STATE OF NORTH CAROLINA
DEPARTMENT OF TRANSPORTATION

October 15, 2010

Subject: **Information to comply with Section 401 conditions** for US 401 widening from SR 2044 (Ligon Mill Rd) to north of SR 2226 (Jonesville Rd), Wake County, Federal Aid No. STP-401(4), State Project No. 81403001, WBS 34506.1.1, Division 5, TIP R-2814 A.

PROJECT REFERENCE NO. R-2814A	SHEET NO. EC-5/CONST.5
R/W SHEET NO.	
ROADWAY DESIGN ENGINEER	HYDRAULICS ENGINEER

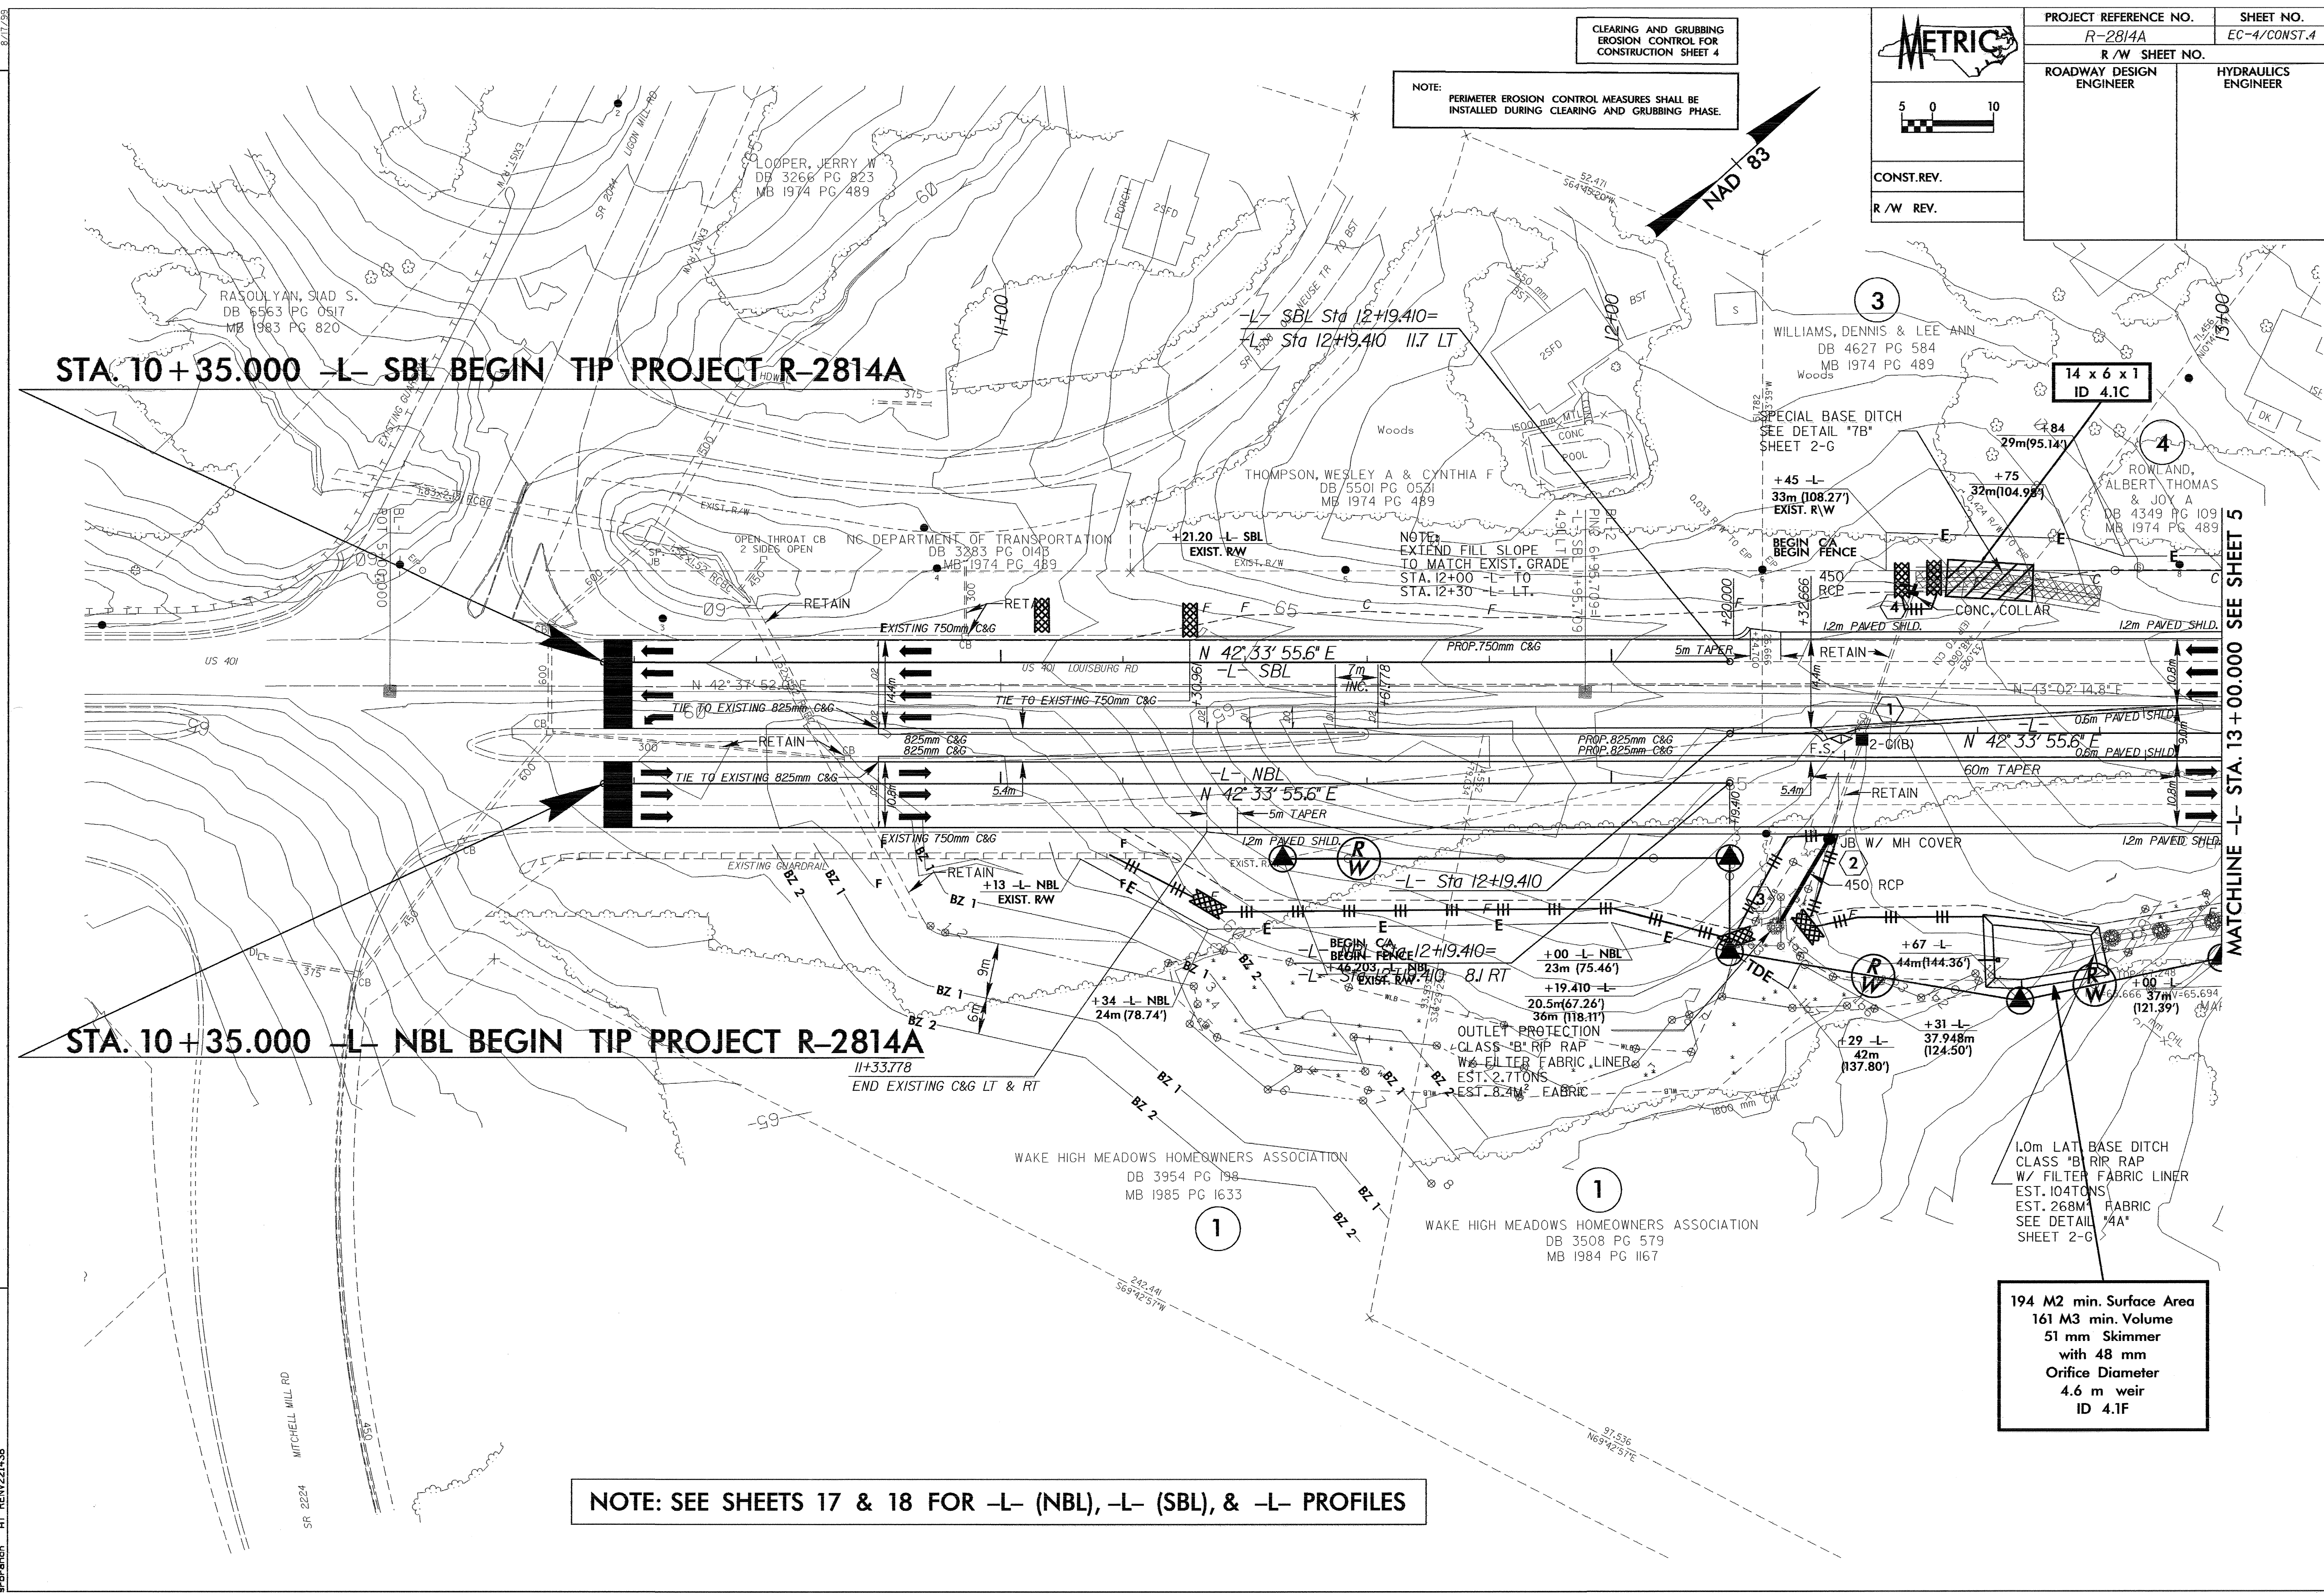
Issue: Stream permit drawings 8 and 9 depict a jurisdictional stream at the outlet of a 600 mm pipe structure at 15+90 Rt. However, a review of construction plan sheet 5 does not depict any stream or channel feature at this location.

Response: Revised construction plan 5 reflects the jurisdictional stream depicted on stream permit drawings 8 and 9.

PROJECT REFERENCE NO. R-2814A	SHEET NO. EC-12/CONST.12
ROADWAY DESIGN ENGINEER	HYDRAULICS ENGINEER

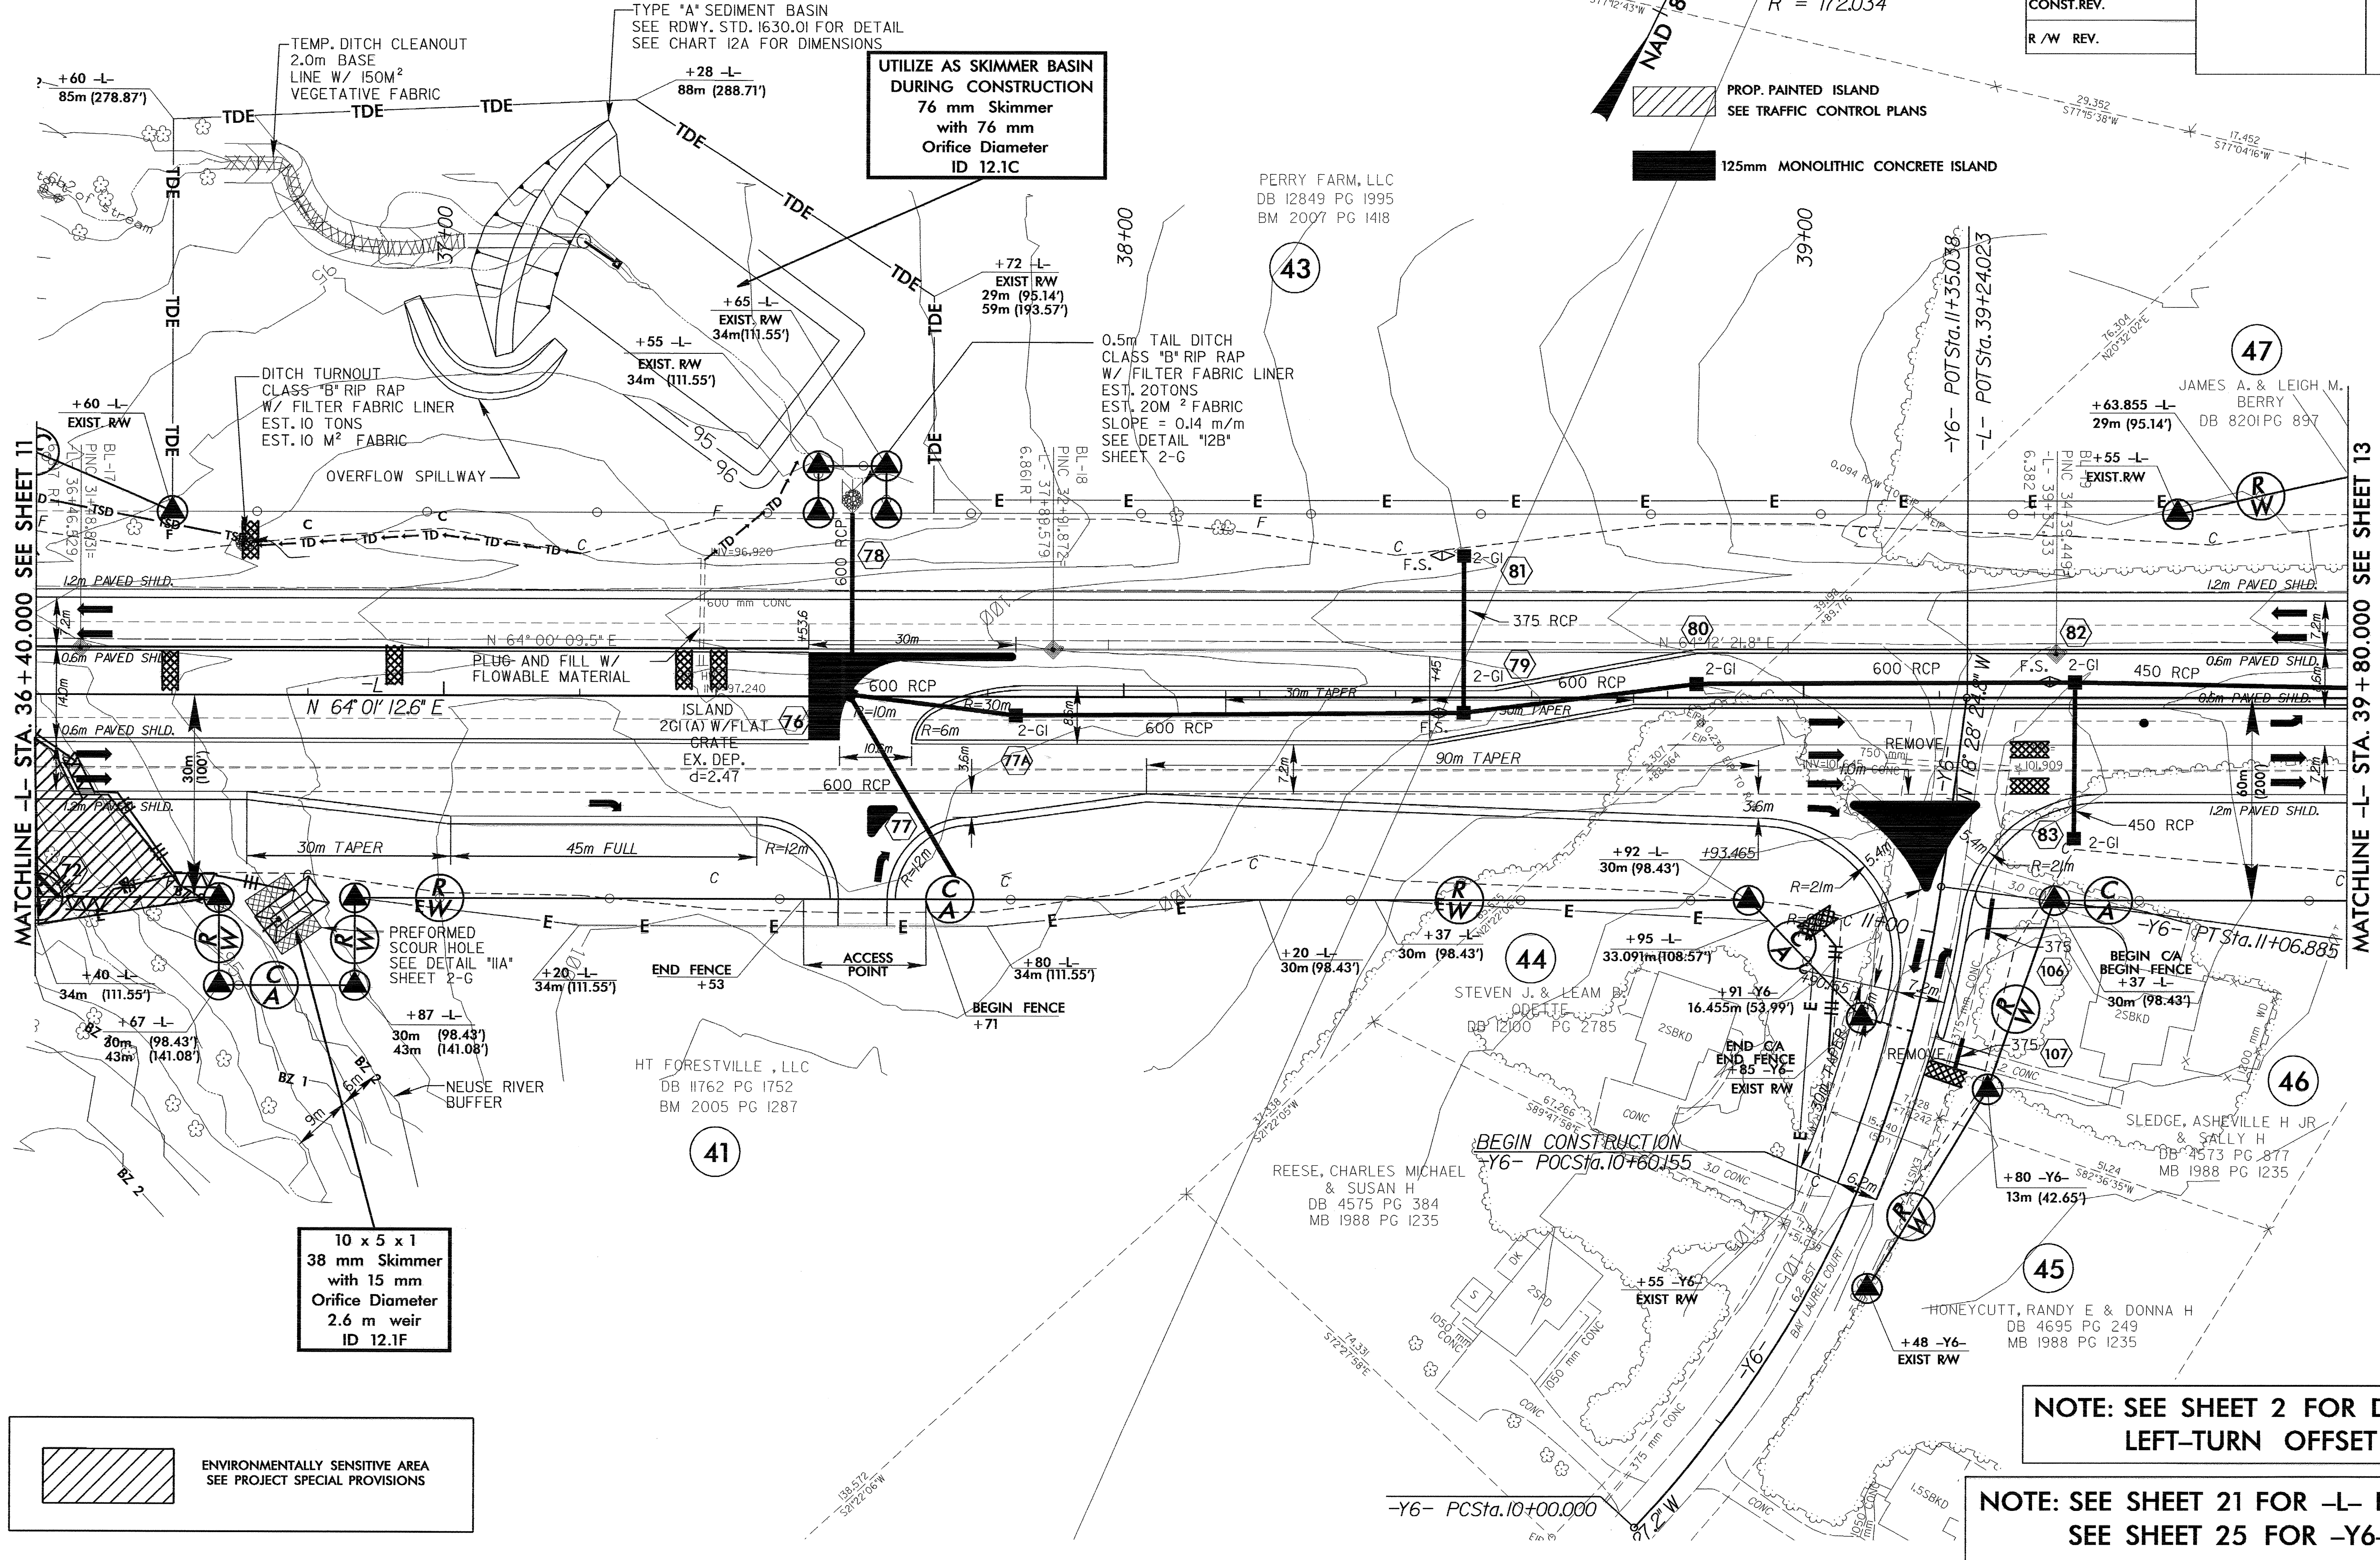
Issue: Construction plan sheet 12 depicts a ditch turnout with rip rap at the high end of a PFSH located at 36+80 Rt. Stream permit drawings 14 and 15 and buffer permit drawing 9 depict no ditch turnout with rip rap at the high end of the PFSH.

Issue: A headwall has been designed to be installed at the inlet of a 1050 mm pipe structure at Station 36+45 Rt.

Response: This construction revision has been depicted on revised construction plan 12, revised stream permit drawings 14 and 15, and revised buffer permit drawing 9
